Appeal Decision

Appeal Ref: APP/C3810/D/12/2172586

69 The Fairway, BOGNOR REGIS, West Sussex, PO21 4HE

- The appeal is made under section 78 of the Town and Country Planning Act 1990 against a refusal to grant planning permission.
 - The appeal is made by Mr H Evans against the decision of Arun District Council.
 - The application Ref AW/281/11/ was refused by notice dated 19 January 2012.
 - The development proposed is described as 'erection of a single storey non permanent garden shed to the rear of the property'.
-

Drwg Title:
Proposed
Work

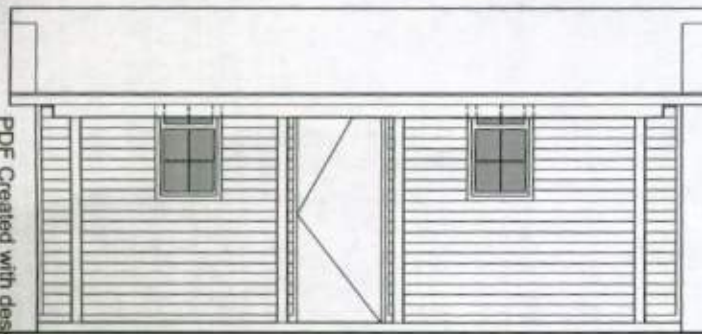
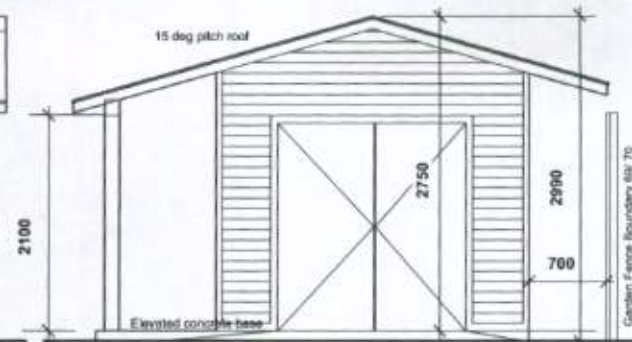
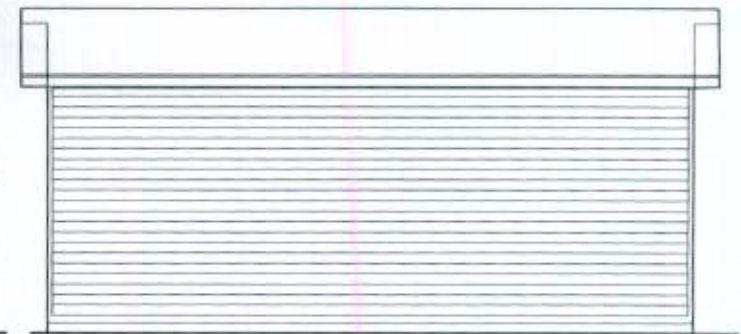
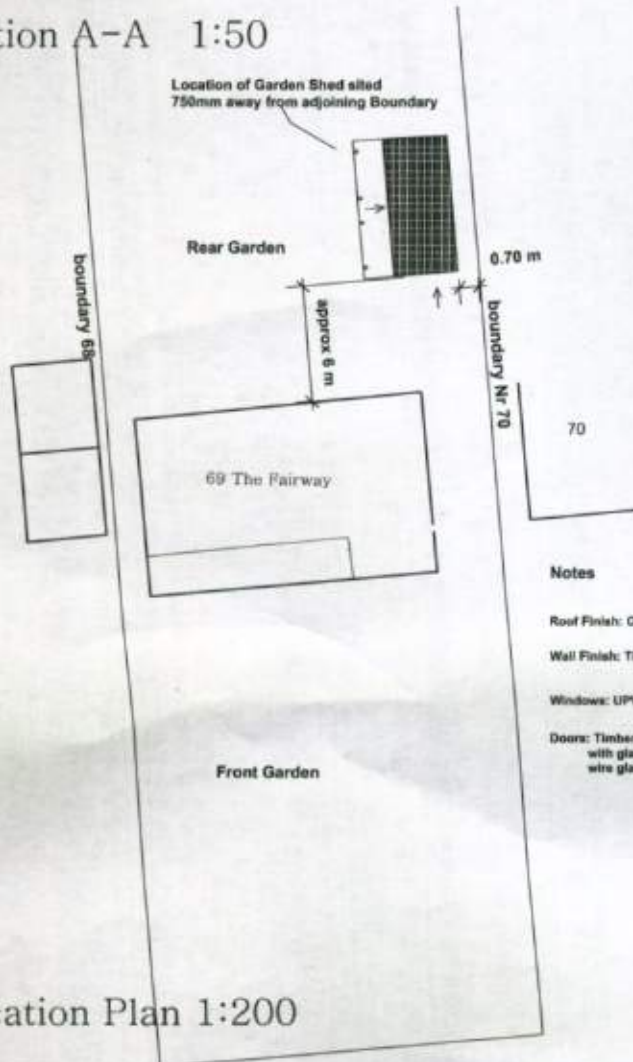
3. The outbuilding the subject of this appeal has been erected and planning permission is sought to retain that building. The erection of this outbuilding followed the demolition of a former, smaller shed. The outbuilding is located alongside the boundary with the adjoining house of No. 70. I saw at my site visit that other properties in the area see rear outbuildings or rearward extensions close to the boundaries with neighbouring properties; that can be seen at the adjoining houses on either side of the appeal property. The location of the outbuilding in question is therefore not objectionable in itself. However, the height of the outbuilding, when combined with this positioning, does create an over-dominant effect upon the outlook of the adjoining house of No. 70. An intervening fence or new planting may reduce this impact to a degree, but not to a sufficient extent to sufficiently mitigate the harm to outlook that arises from the height of the outbuilding.
